Subject: The Barn, 104 Felpham Road, Felpham - FP/43/19/L

I write to you regarding The Barn, 104 Felpham Road, Felpham – reference FP/43/19/L, I am now the Planning Officer dealing with your application.

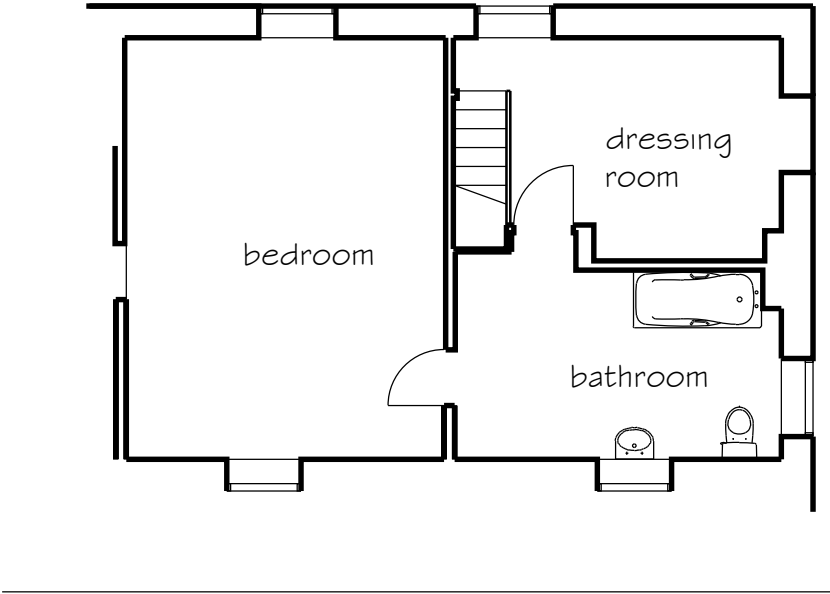
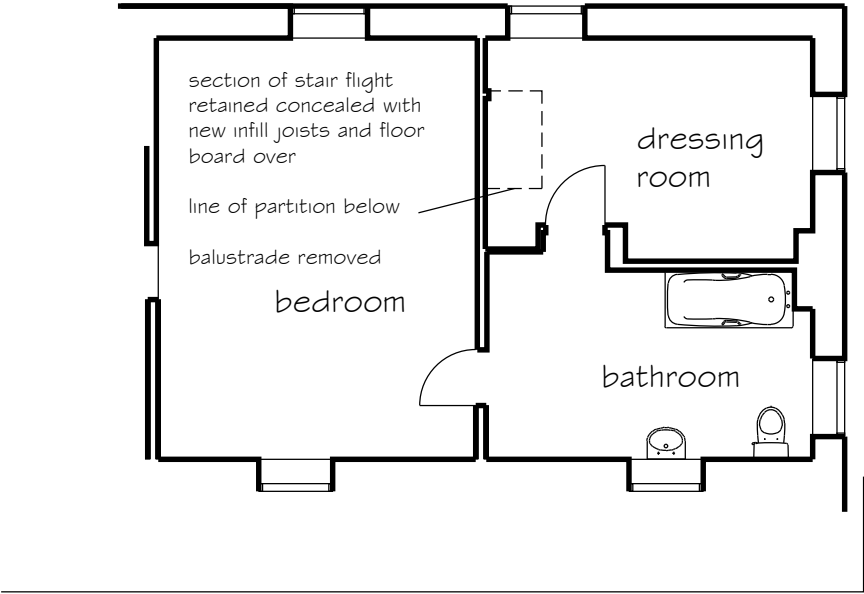
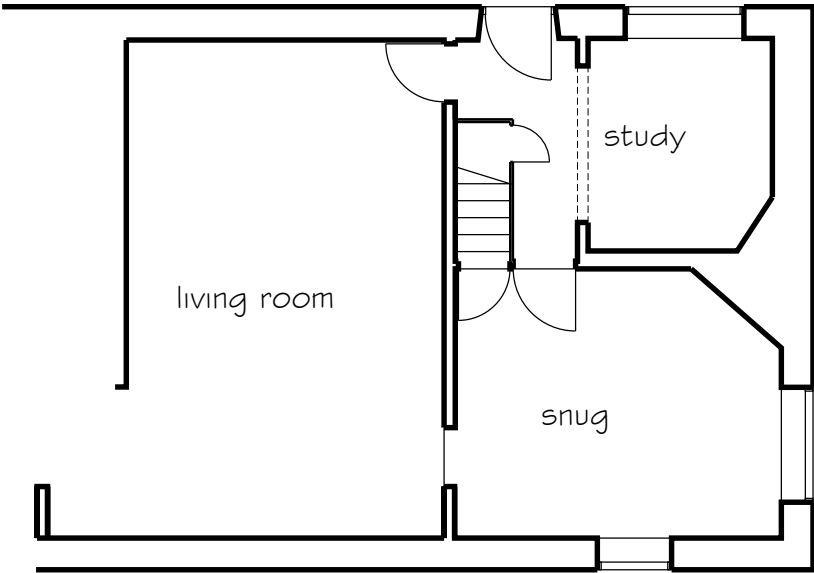
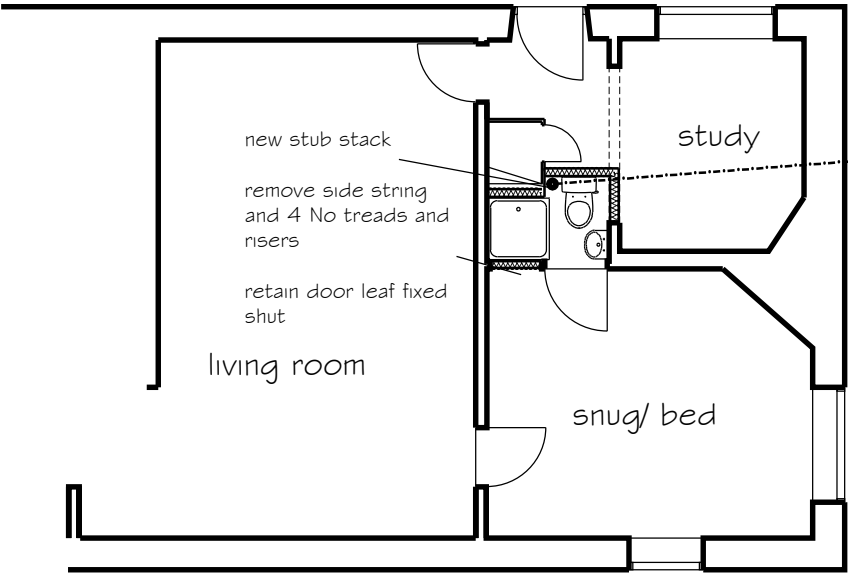
- a further in depth Heritage statement which includes details of the exact proposed works to the stairs and what the impacts will be to the existing dwelling and full justification of the proposed works.
- further details of the proposed stairs that are required are as follows, what impact will there be on the existing stairs? How does the applicant propose to enclose the stairs and keep the stairs in-keeping with the Listed building? Will the stairs be exposed or not and how will they be secured?
- Also, details on the extraction facilities of the proposed shower room.
